Memorandum

From
MR. S. K. SINGH - SECRETARY,
Special Metropolitan
Development Authority,
No. 5, Gandhi Drive Road,
Chennai - 600 026.

Sub: CRS - 100 - 20 - Proposed construction of open back
alley for 12 lots at 101, 102, 103, 104, 105, 106, 107,
108, 109, 110, 111, 112, 113, 114, 115, 116, 117, 118, 119,
120, 121, 122, 123, 124, 125, 126, 127, 128, 129, 130,
131, 132, 133, 134, 135, 136, 137, 138, 139, 140, 141,
142, 143, 144, 145, 146, 147, 148, 149, 150, 151, 152,
153, 154, 155, 156, 157, 158, 159, 160, 161, 162, 163,
164, 165, 166, 167, 168, 169, 170, 171, 172, 173, 174,
175, 176, 177, 178, 179, 180, 181, 182, 183, 184, 185,
186, 187, 188, 189, 190, 191, 192, 193, 194, 195, 196,
197, 198, 199, 200, 201, 202, 203, 204, 205, 206, 207,
208, 209, 210, 211, 212, 213, 214, 215, 216, 217, 218,
219, 220, 221, 222, 223, 224, 225, 226, 227, 228, 229,
230, 231, 232, 233, 234, 235, 236, 237, 238, 239, 240,
241, 242, 243, 244, 245, 246, 247, 248, 249, 250, 251,
252, 253, 254, 255, 256, 257, 258, 259, 260, 261, 262,
263, 264, 265, 266, 267, 268, 269, 270, 271, 272, 273,

SITE PLAN.

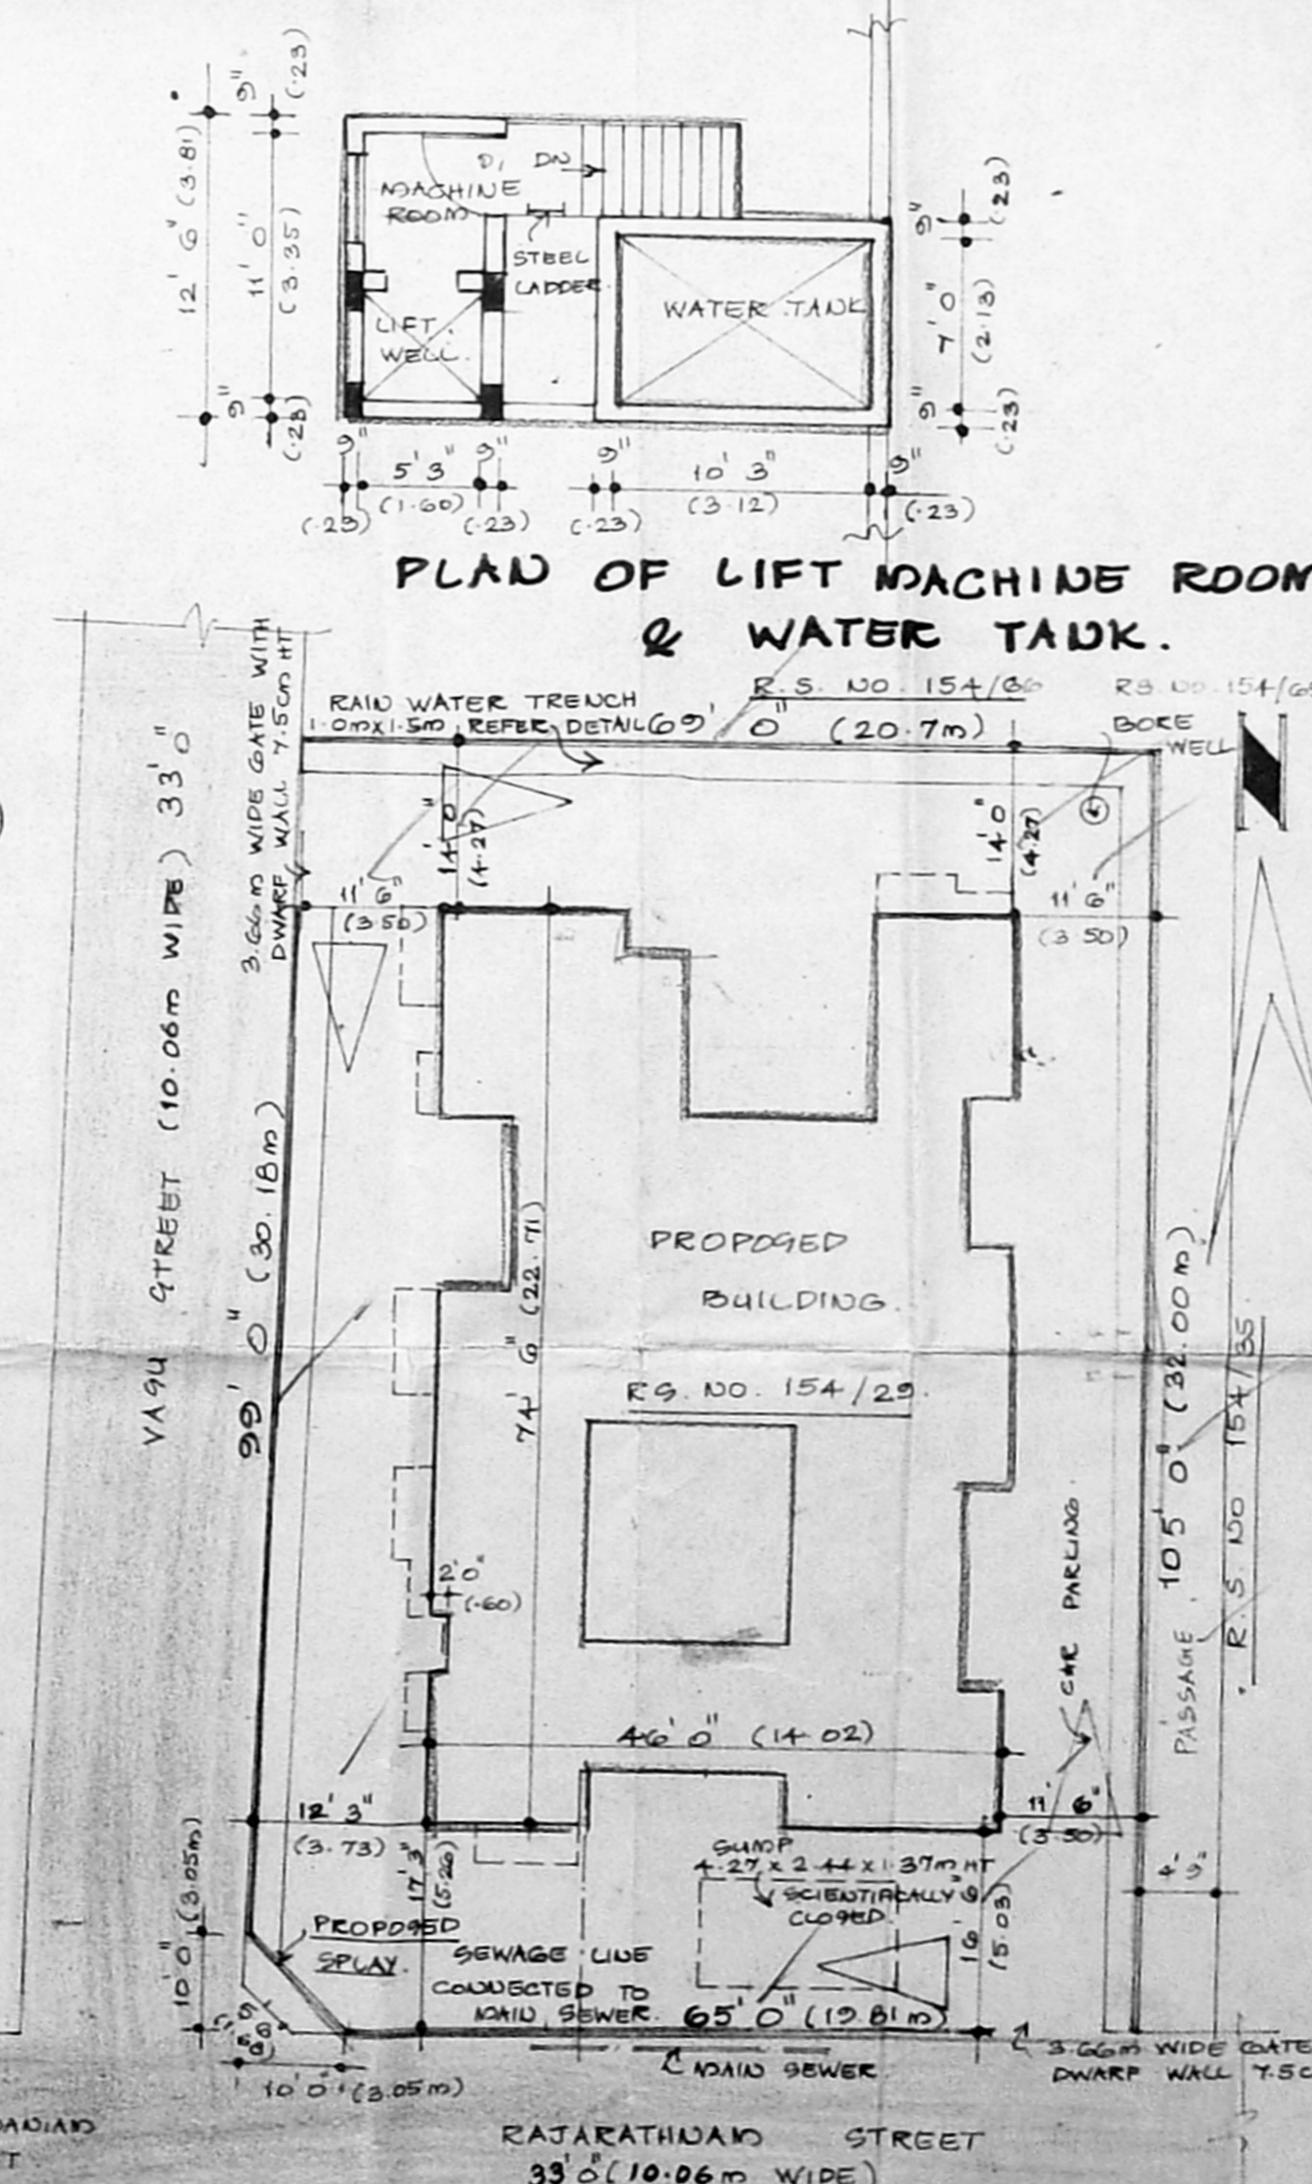
(2) (c) The final fee copies of revised plan showing a front of 20.5 m and revised a wall to 2.75 m as per layout plan to the periphery of the site and circulation plan and deed for the edge ridge to the site etc.
